Development Review Board (DRB)
Review Comments
Utility Development Section
Reviewer: Blaine Carter, P.E.
Phone: 505.415.9188

DRB Project No: PR-2021-005195	Date: 12/01/21	Item No: #7
Zone Atlas Page: D-17	Legal Description: Tract 6A-1, Unit 1, Journal Center Phase 2 Location: STREETS 7501 JEFFERSON ST NE between JEFFERSON ST and MASTHEAD ST NE	
Request For: SI-2021-01747 – SITE PLAN

DEKKER/PERICH/SABATINI – WILL GLEASON agent for **JC SIX LLC** requests the aforementioned action(s) for all or a portion of: **TRACT 6A-1, UNIT 1, JOURNAL CENTER PHASE 2** zoned MX-H, located on **7501 JEFFERSON ST NE** between **JEFFERSON ST** and **MASTHEAD ST NE** containing approximately **5.1536** acre(s). (**D-17**)

1. SITE PLAN APPROVAL REQUEST FOR MULTI-FAMILY APARTMENT HOME COMMUNITY

C1 SECTION @ JEFFERSON
1/8" = 1'-0"

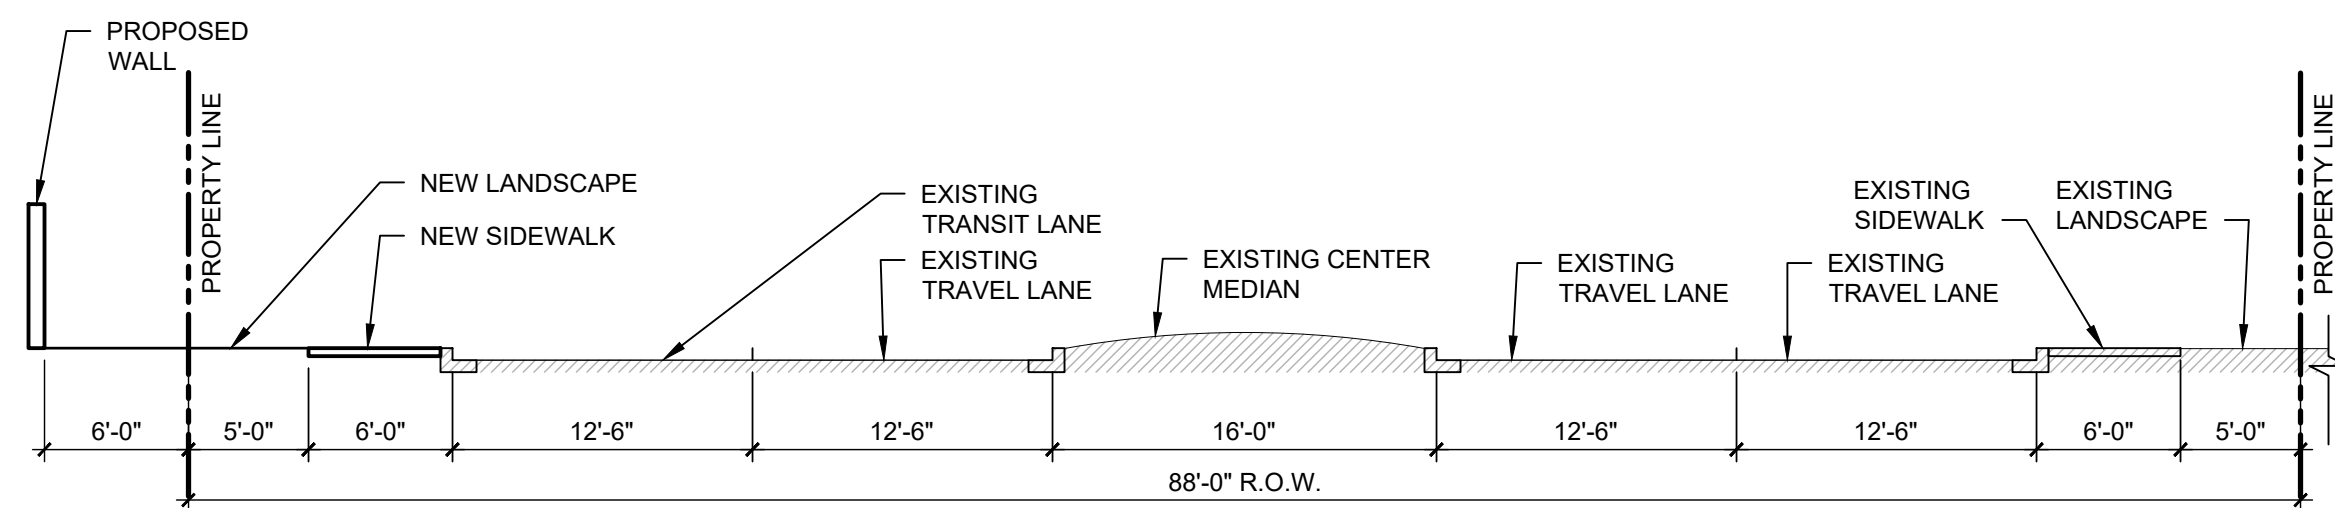
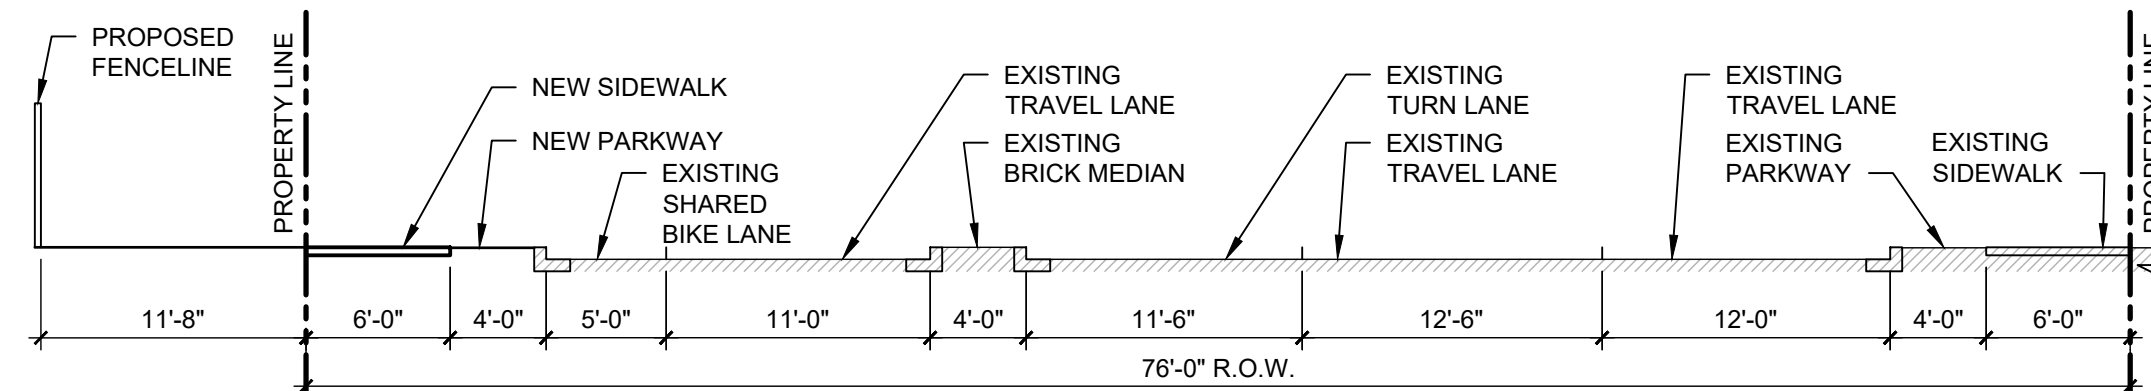
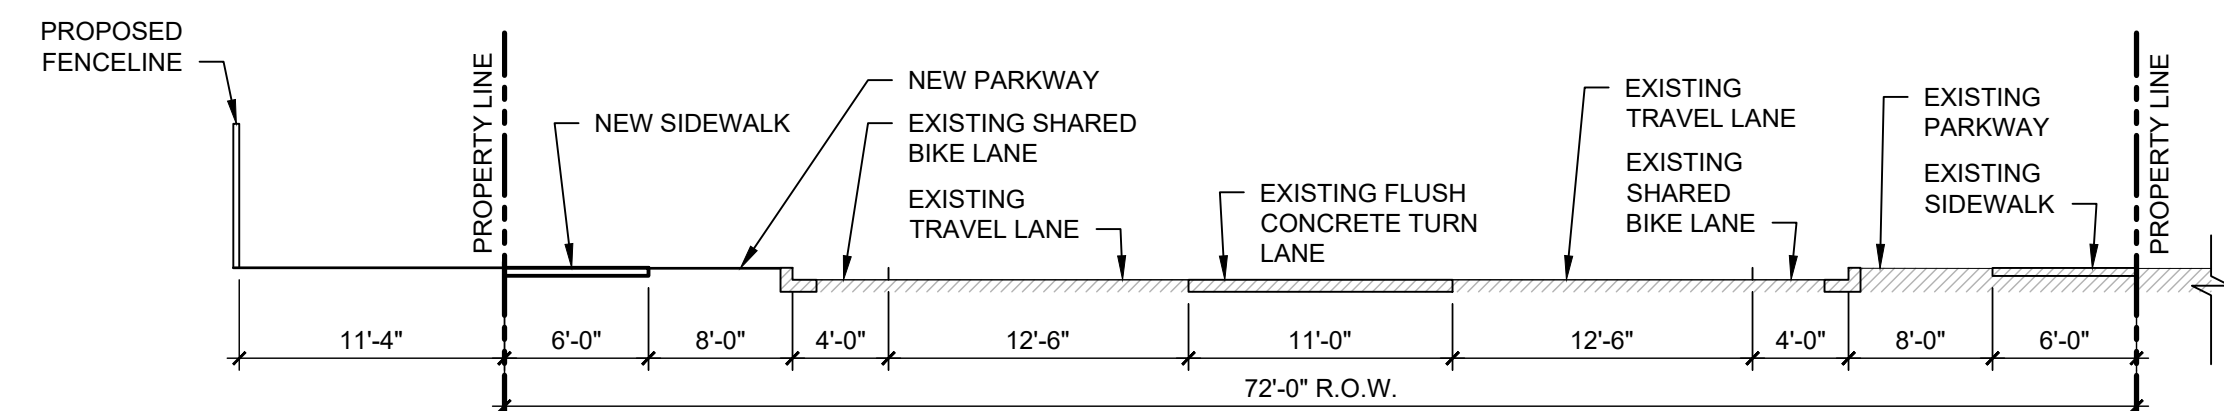
9. Bike lane markings are required on Tiburon Street and Masthead. A buffered bike lane is proposed for Jefferson Street. On a cross-section for each road, indicate these proposed facilities while following guidelines to terminate markings in advance of the roundabout. On Jefferson Street, make sure sufficient space is given to bike facilities for future development.

Response – See sections C1, D2, and D4 on SDP1.3 for existing and proposed conditions.
